Town & Country Planning Act 1990 (as amended)
Town and Country Planning (Development Management Procedure) (England) Order 2015

Demolition of 1 No. existing house & grounds & erection of 2 No. new detached dwellings. This application may affect the character & appearance of the Station Road, East Preston Conservation Area.

St Marys Close Hurst Road Rustington

We both strongly object to Planning Application - Reference R/190/18/PL proposal for the following reasons :

Drawing Title:
ADDITIONAL DWELLINGS
BLOCK/ SITE PLAN

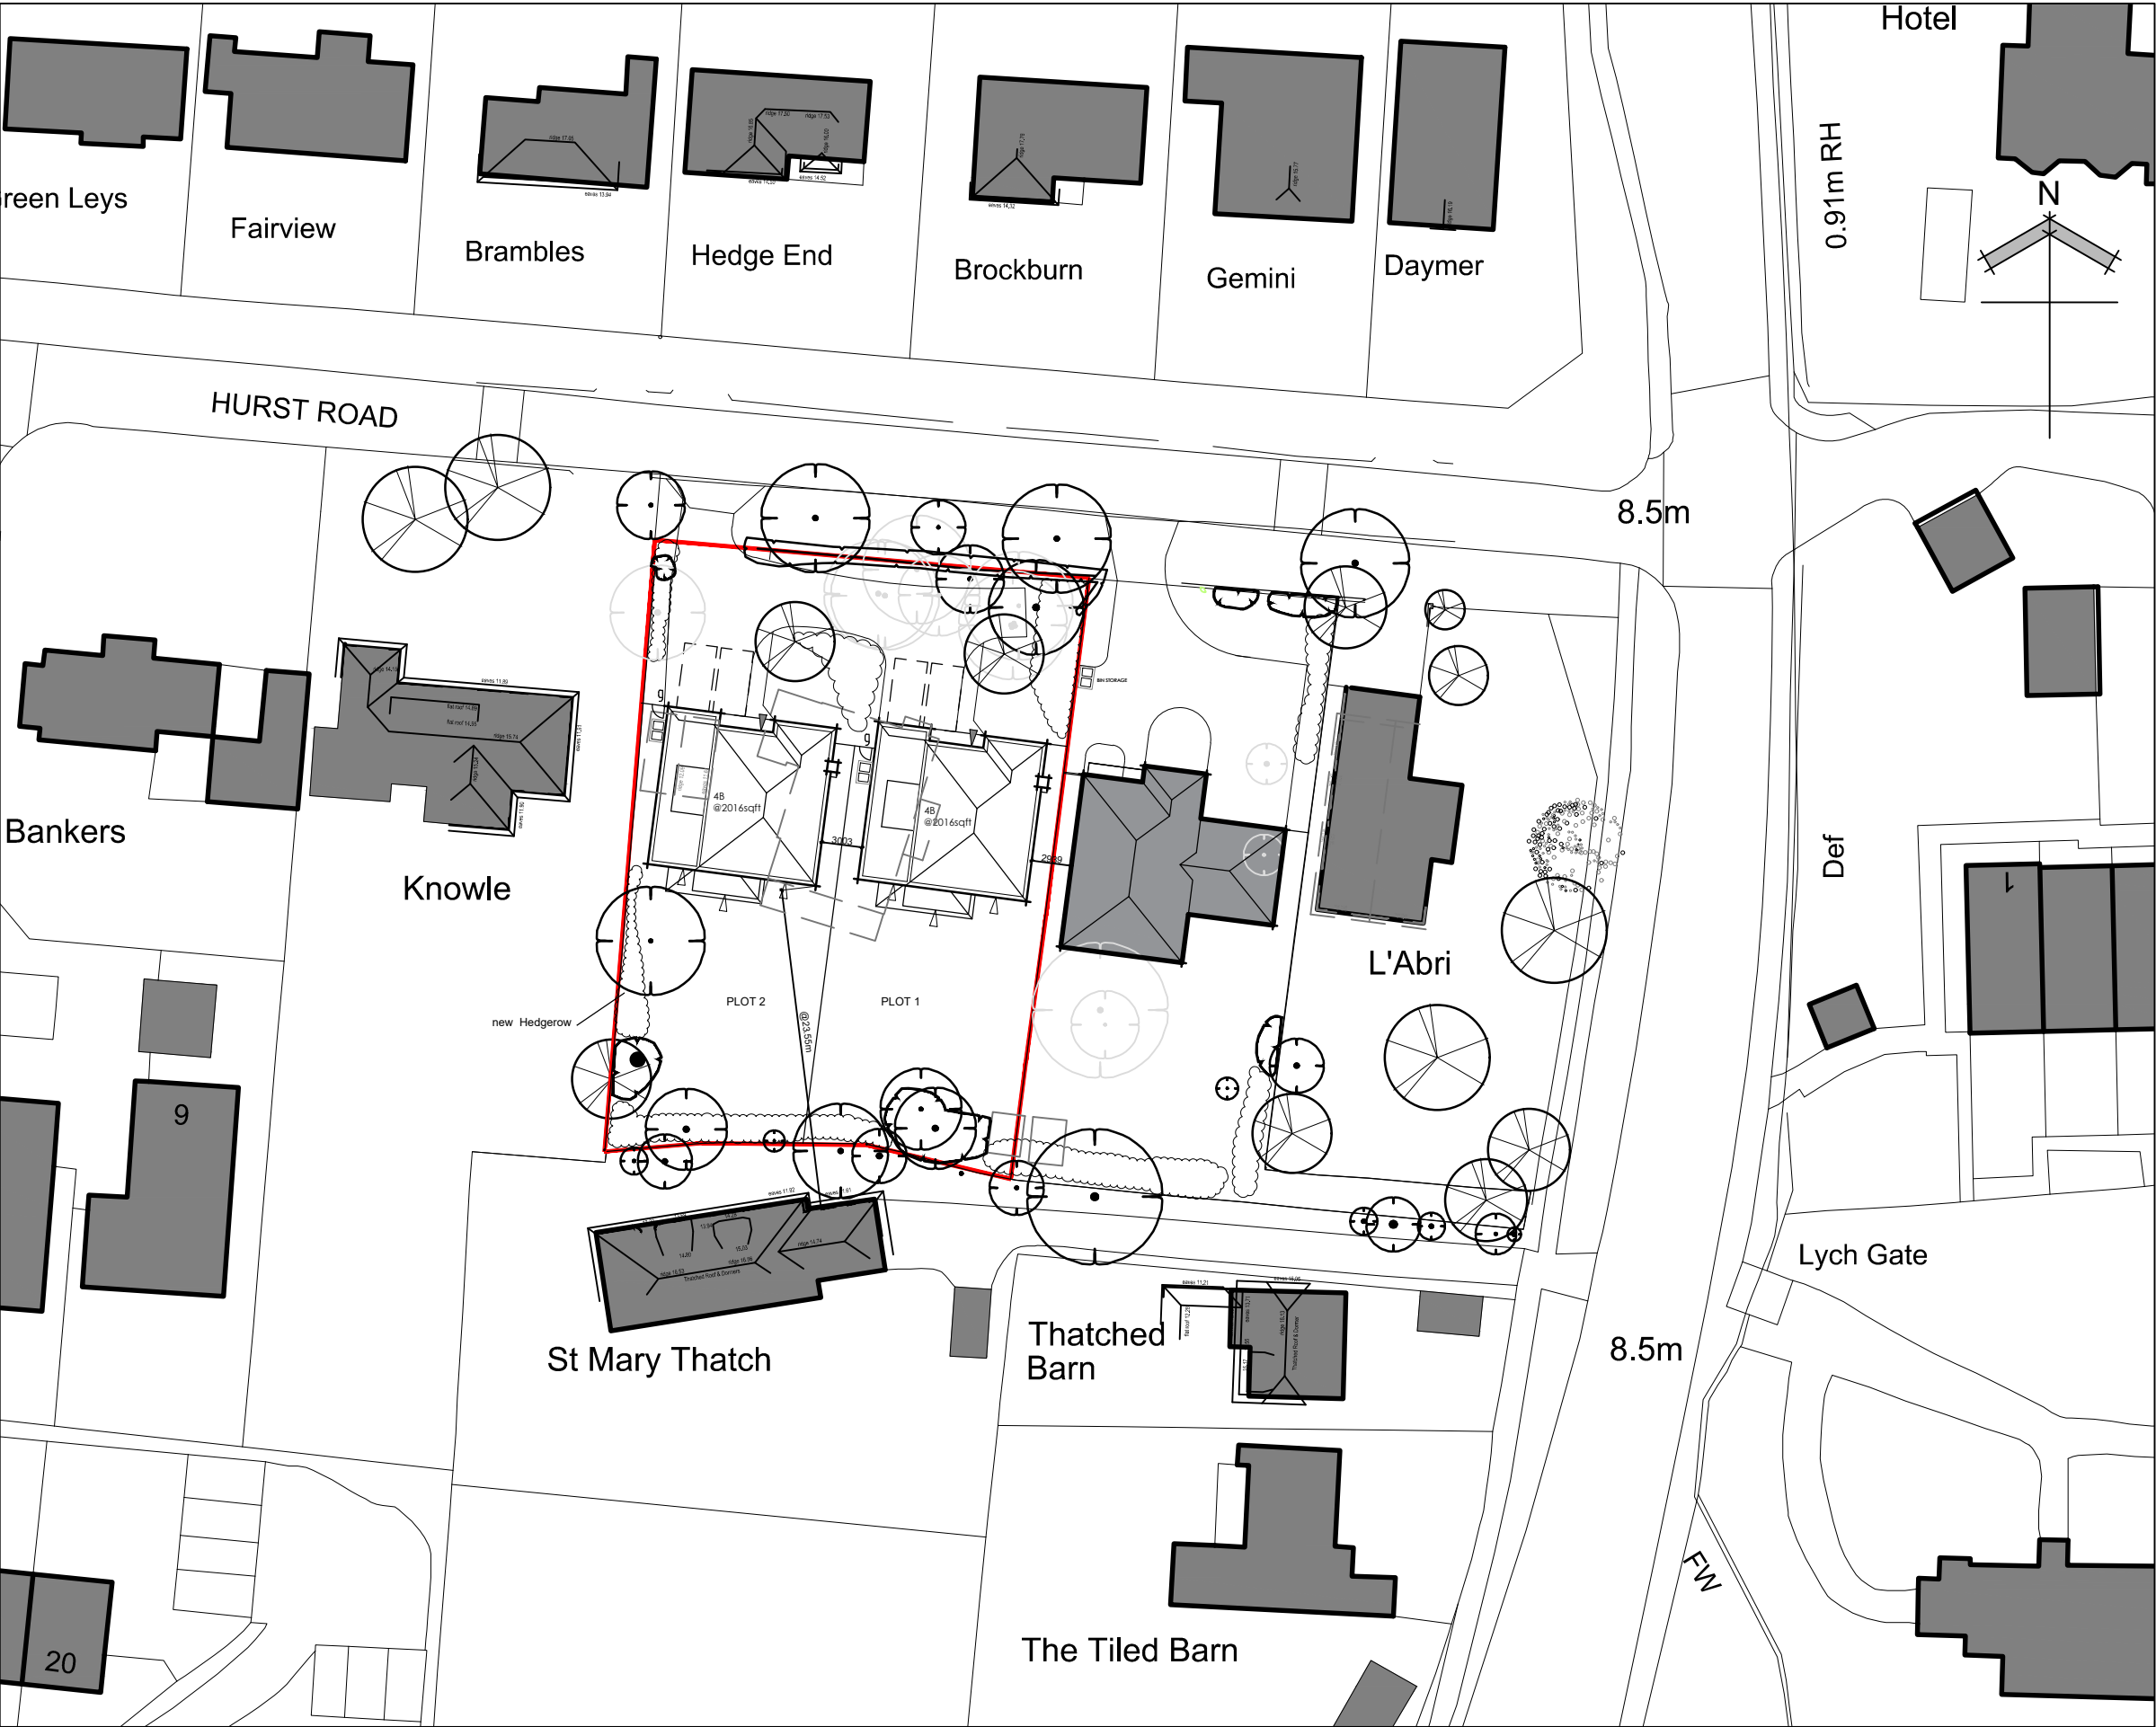
The fact that these two properties have a shared drive could cause problems and arguments later, with the result that cars could be parked on Hurst Road.

- 1. That these 2 properties are identical unlike the rest of the road.*
- 2. That these 2 properties share one driveway as apposed to the properties in the rest of the road, which have their own drive.*
